## Engineers Comments Regarding Surface Water Drainage

<b>Application Reference:</b>	AL/107/25/PL	<b>Reviewer Reference:</b>	ADC/EXT5/AF
<b>Planning Officer:</b>	Simon Davis	<b>Date of Review:</b>	8/12/2025
<b>Site Name:</b>	Land at West Barn Old Dairy Lane Norton PO20 3AF		
<b>Application Description:</b>	Demolition of existing tennis court and erection of a commercial building (within Use Class E(g)), parking, landscaping and other associated works. This application is a departure from the Development Plan, may affect the character and appearance of the Norton Lane, Norton Conservation Area and is in CIL Zone 3 (Zero Rated) as other development.		
<b>Assessment Number:</b>	1

**TYPICAL DETAILS OF SOAKAWAY USING MODULAR UNITS**

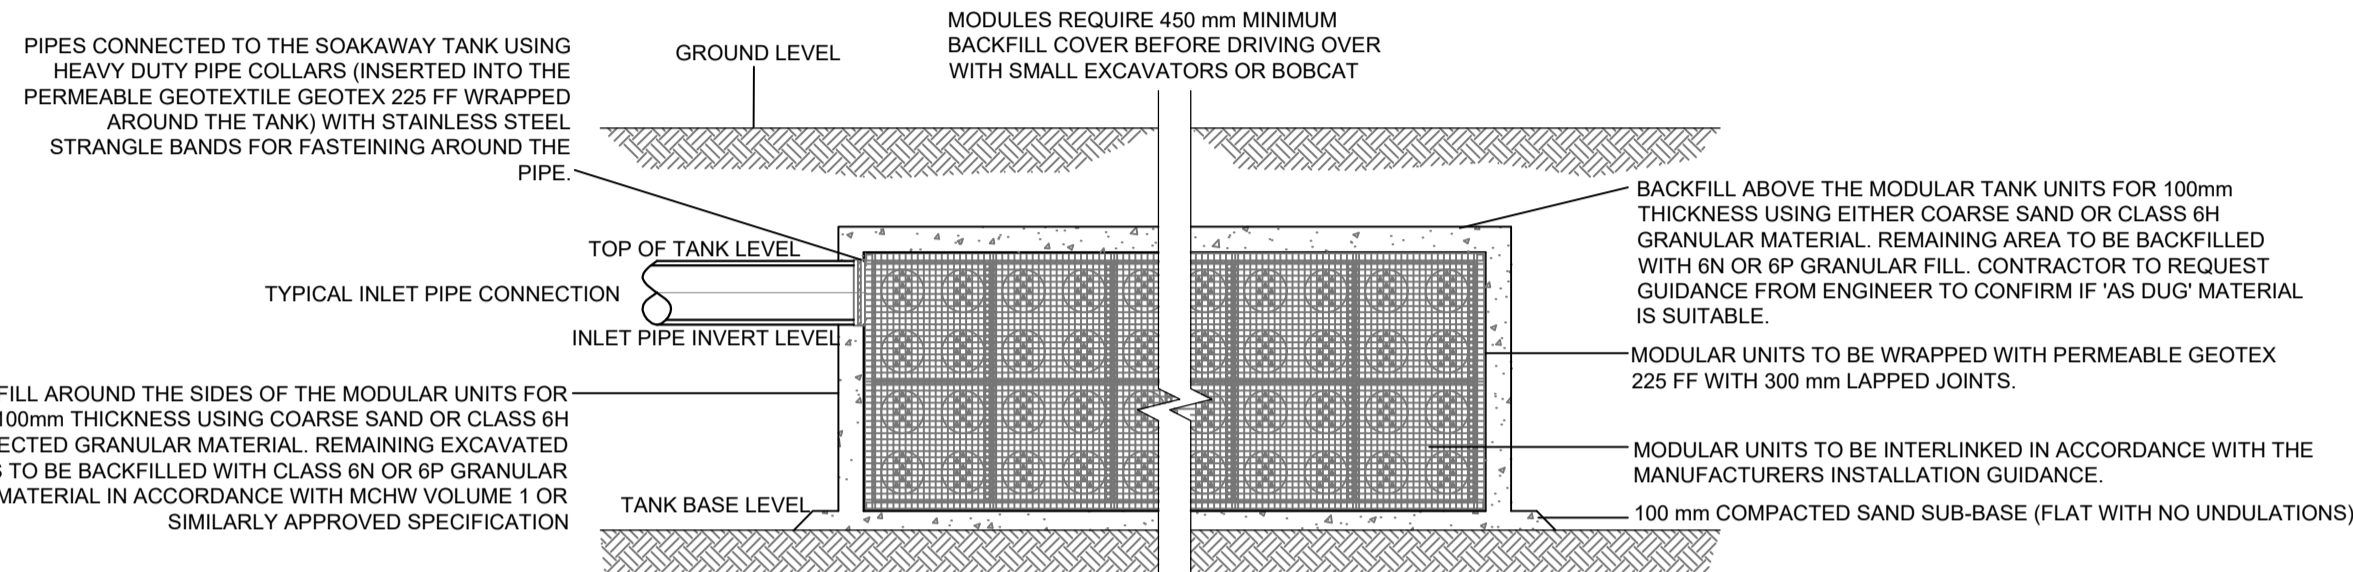
- 1.1. The drainage strategy is to discharge to ground via a modular crate storage soakaway. Currently no winter groundwater monitoring has been provided. Ground Investigation including the locations of the borehole record and infiltration test, together with soil classification and groundwater monitoring is required to demonstrate the proposed method of disposal can meet design standards.

- 1.2. Advice: It is common for there to be a flow for groundwater within the gravel layers around Chichester including artesian effects during high groundwater events from the pressure head created by the South Downs. It is therefore unlikely that the proposed infiltration solution will be acceptable.

- 1.3. Whilst the existing drainage is reported to discharge to soakaway, evidence is required to confirm the proposed development meets the sustainable drainage requirements of the NSfS which includes a requirement for a 1m unsaturated zone between infiltration and high ground water which may not be possible in this location.

- 1.4. There are also minimum factors of safety required by the NSfS for infiltration which have not been applied and would increase the size of infiltration system required. Justification of the rate applied should be provided.

- 1.5. No alternative method of disposal is proposed should infiltration not be viable and the development is reliant upon the currently drainage strategy which must therefore be demonstrated to be viable at planning stage.

- 1.6. The design is not currently in accordance with the requirements of the NSfS (Standard 1). Therefore, we **object** to the application.
